**From:** [Rob Green](#)  
**To:** [Price, Robert](#)  
**Cc:** [Wilson, Andy](#); [Betts, Simon](#); [A38 Derby Junctions](#)  
**Subject:** RE: A38 Derby Junctions - SoCG McD  
**Date:** 02 April 2020 11:50:45  
**Attachments:** [image001.png](#)

- 1a. My client does not agree to the proposed closure of the A38 access
- 1b. The outcome of the A52 junction modelling is agreed, however, concerns remain over the proposed junction layout and its ability to operate safely. Should you wish to split this point into two elements, then we will agree the junction modelling

CUSTOMER TRACKS

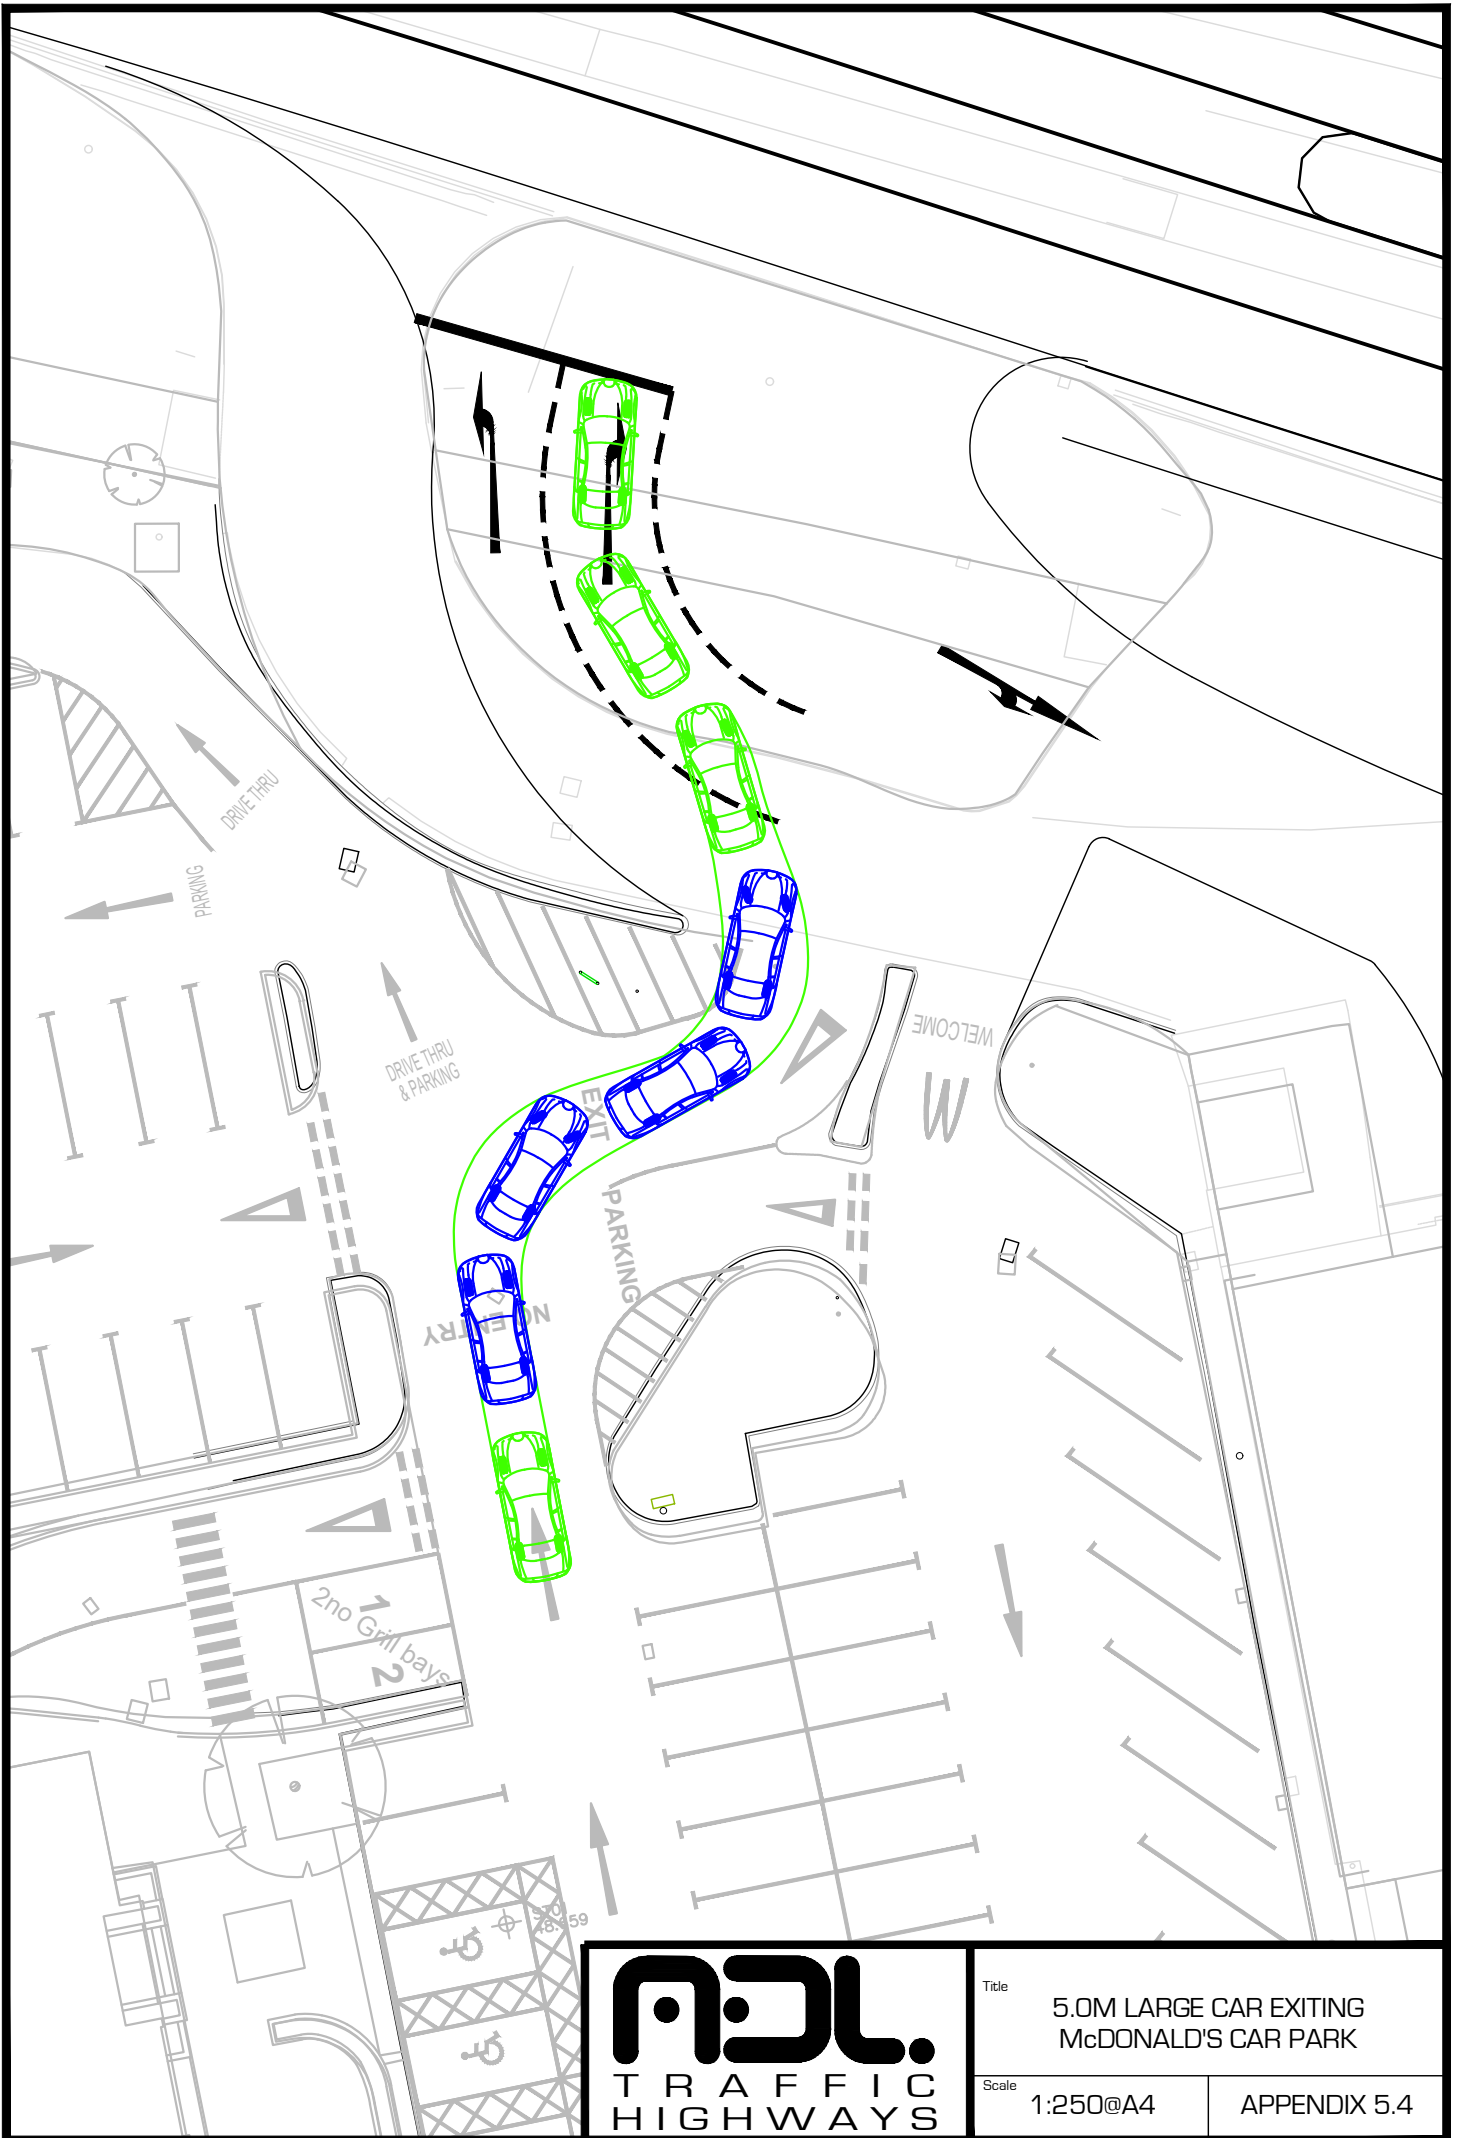
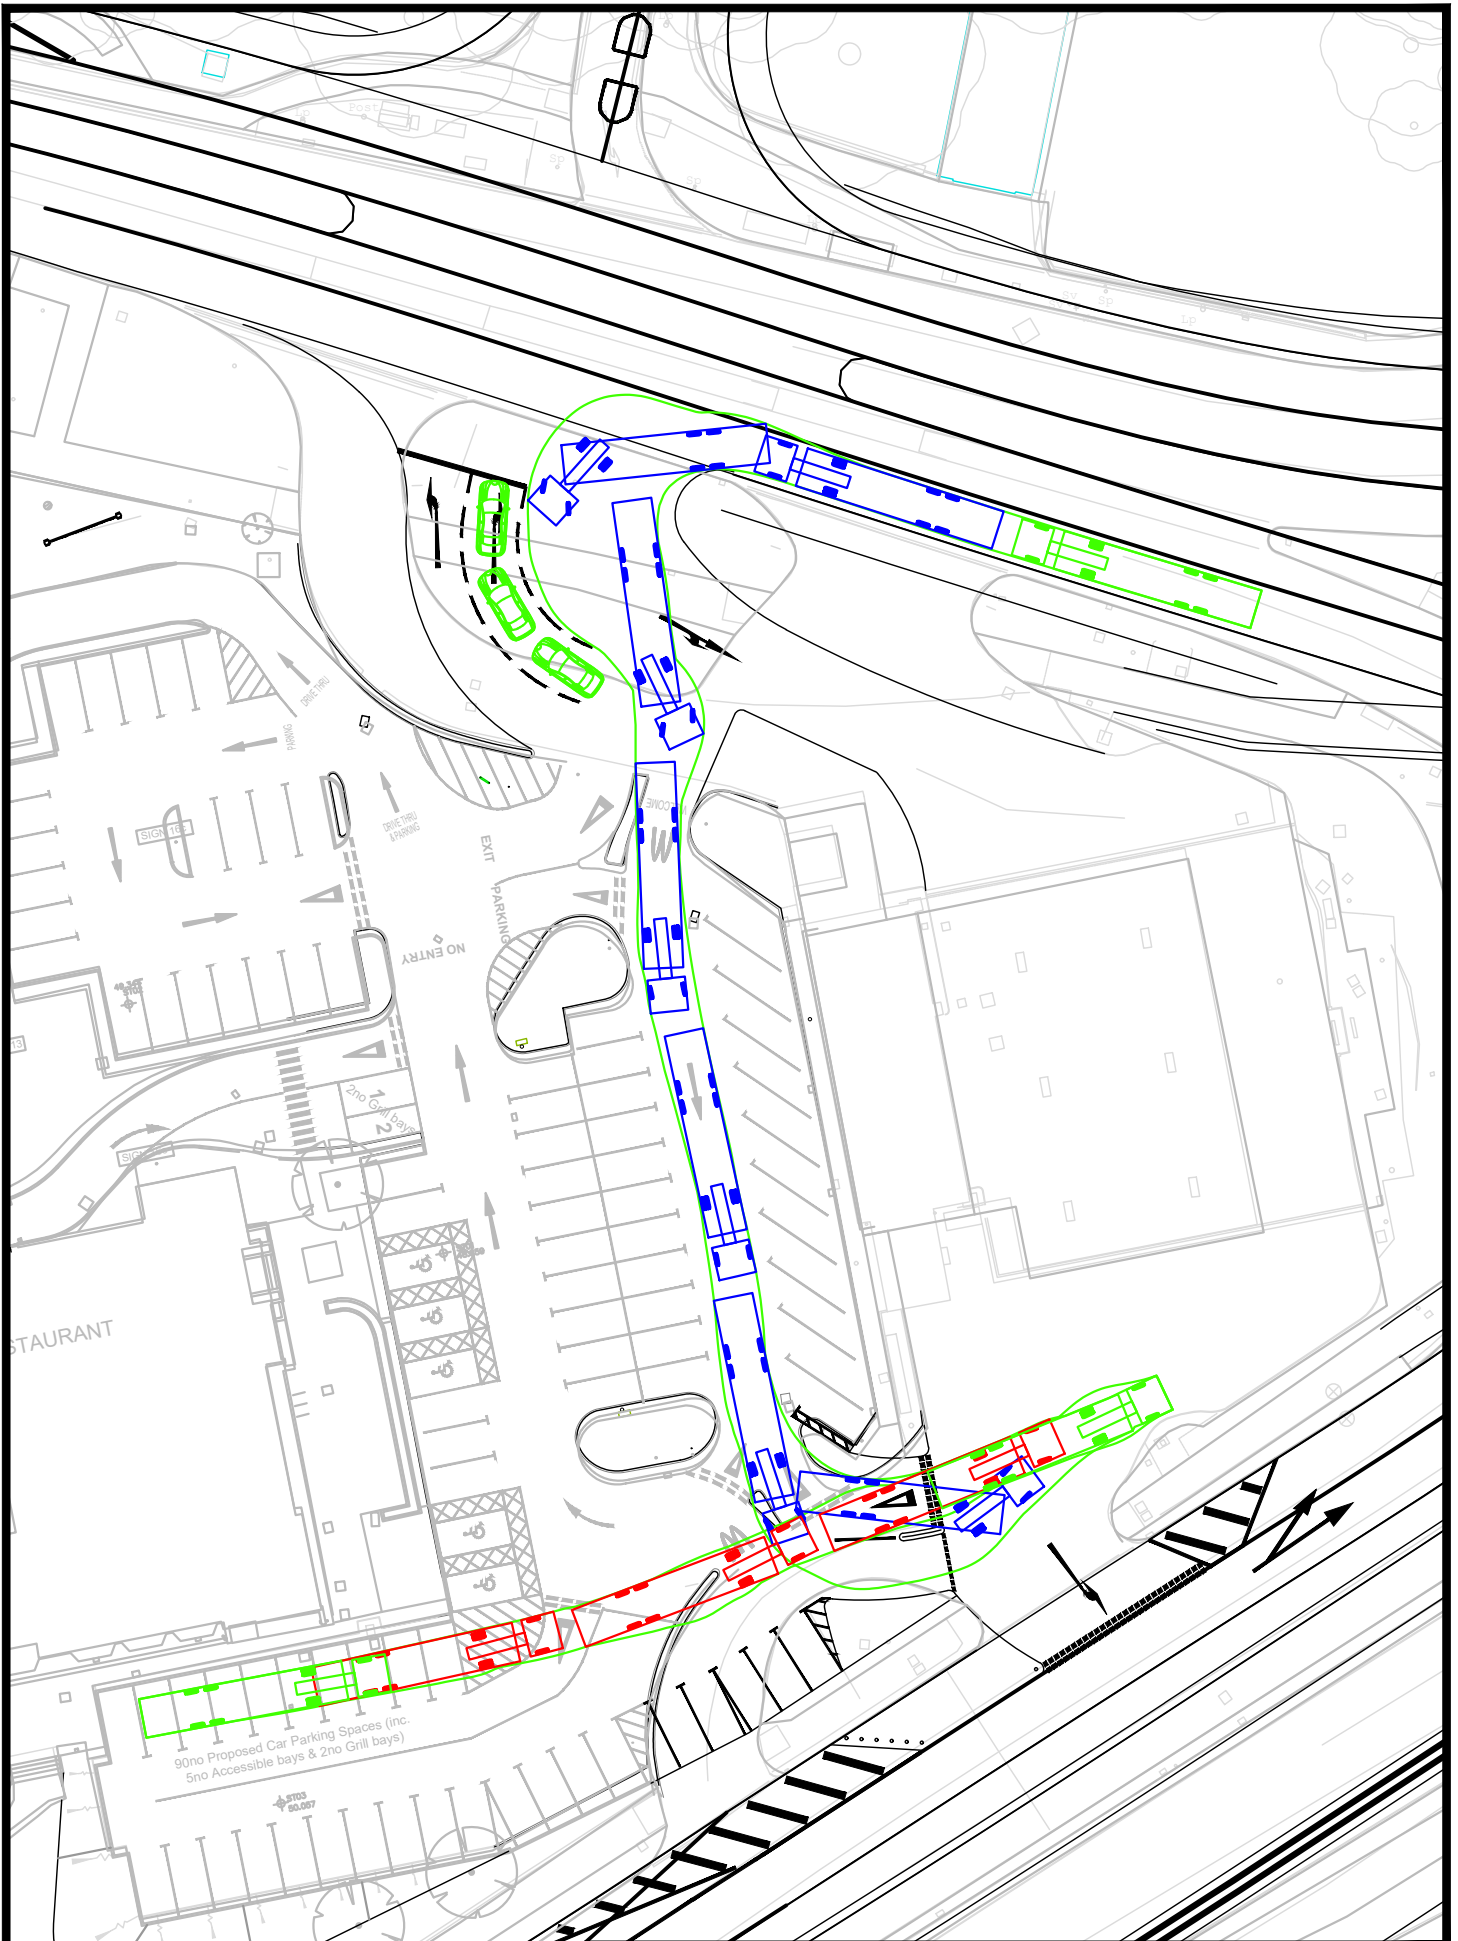
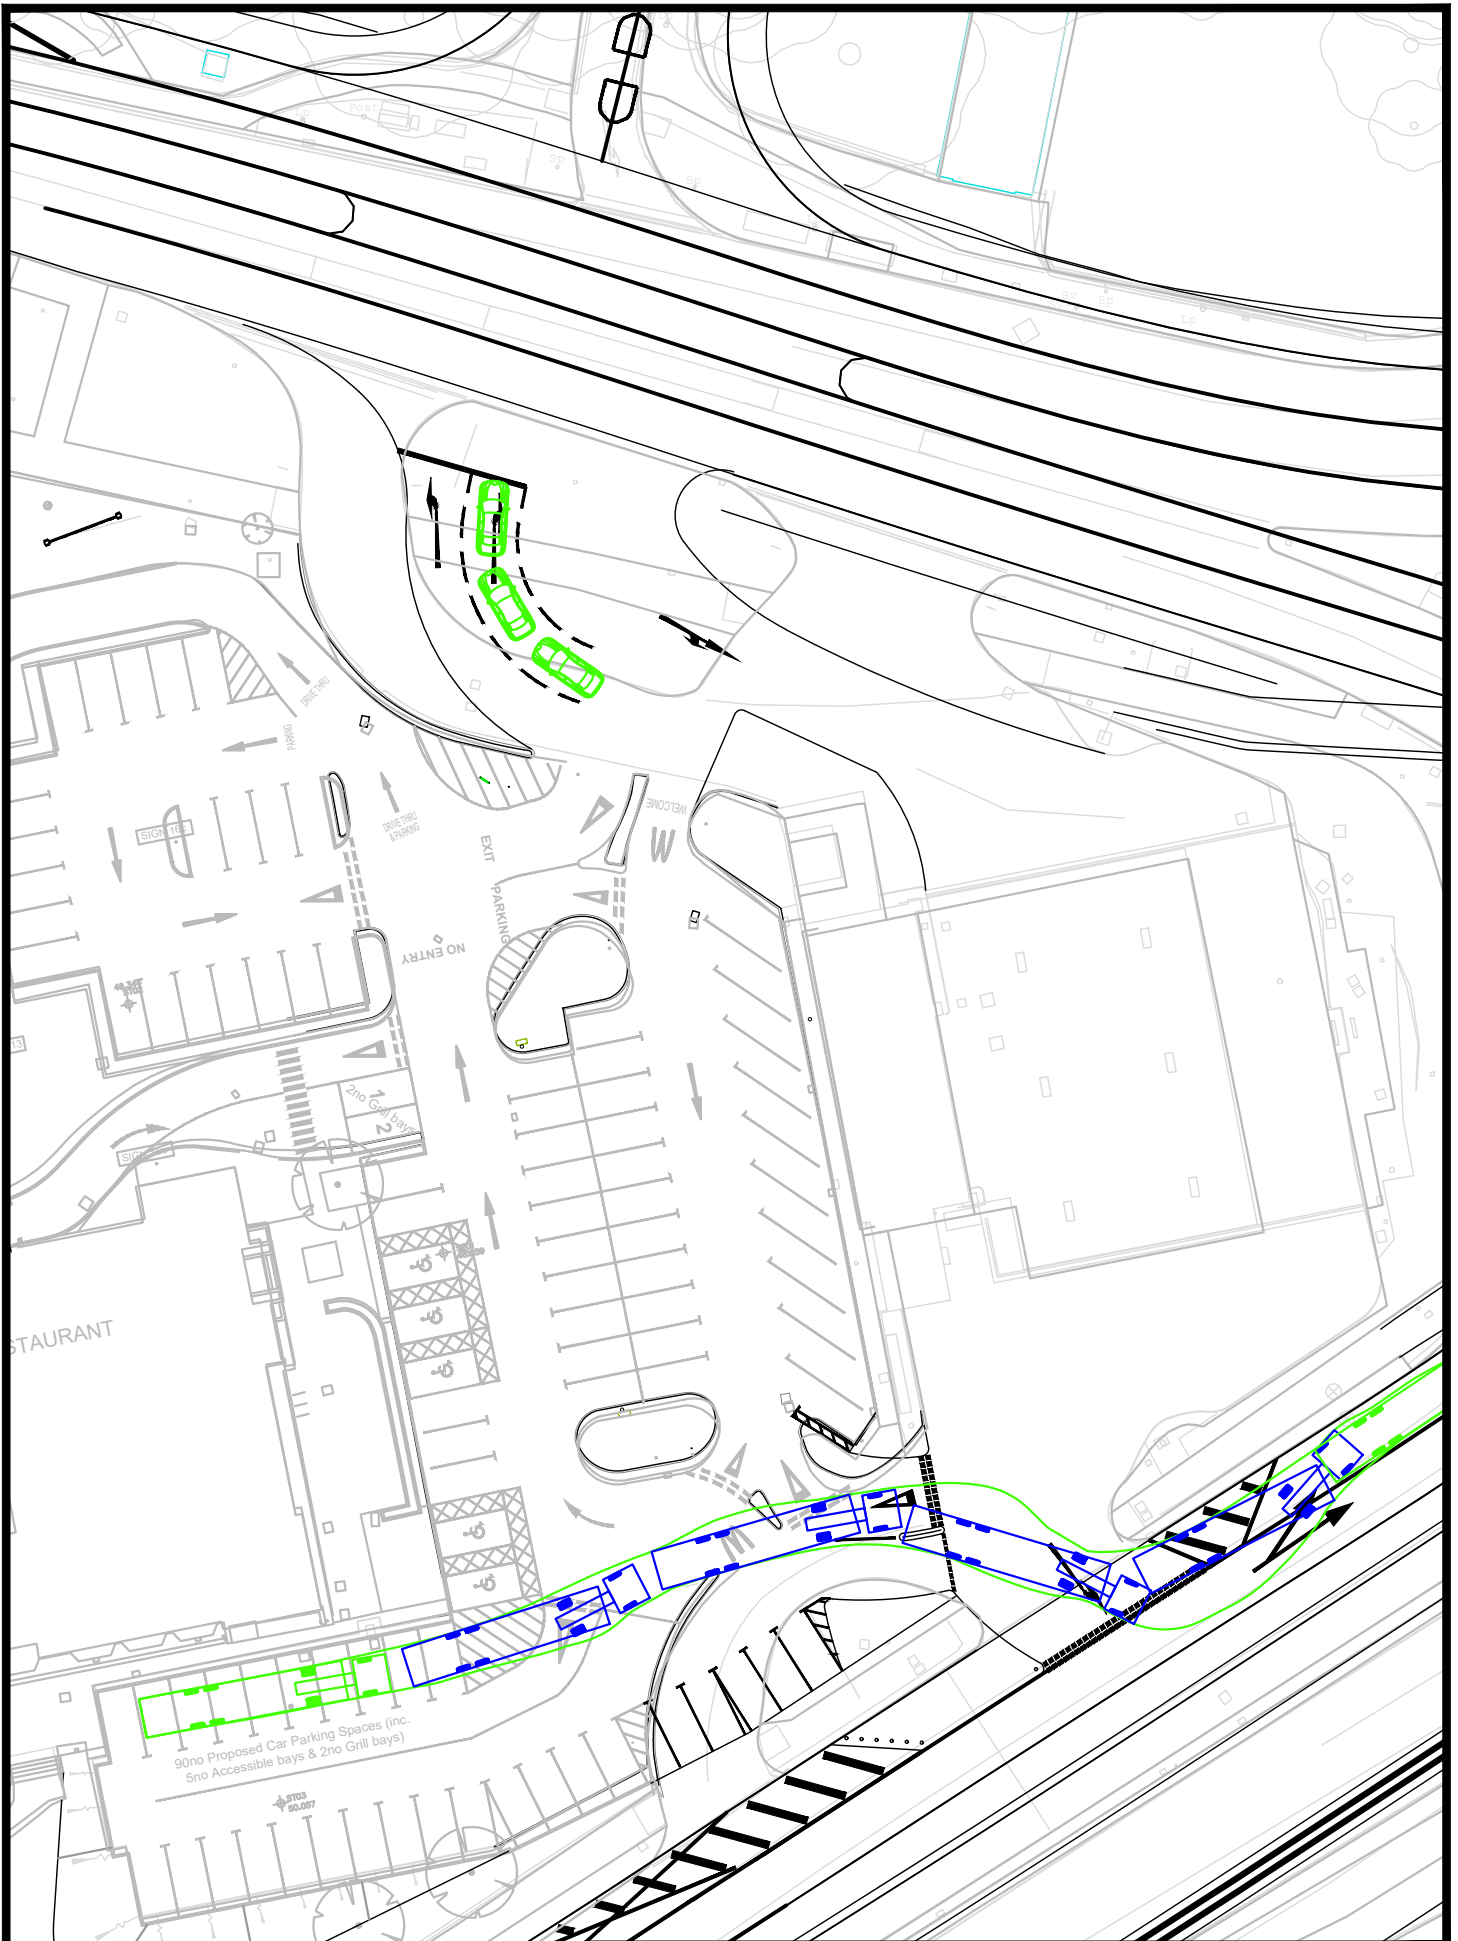
- 2b. Agreed – Servicing via Enfield Road will cease
  - 2c. Agreed – Refuse collection will be via the A52 and McDonald's will accept the management burden of co-ordinating deliveries and refuse to avoid each other arriving at the same time.

- 2d. Not agreed, McDonald's do not have rights for the updated manoeuvres on Euro Garages controlled land.
- 3a. Remains under discussion – if a detailed signal design layout is provided, this can be reviewed further and potentially agreed.
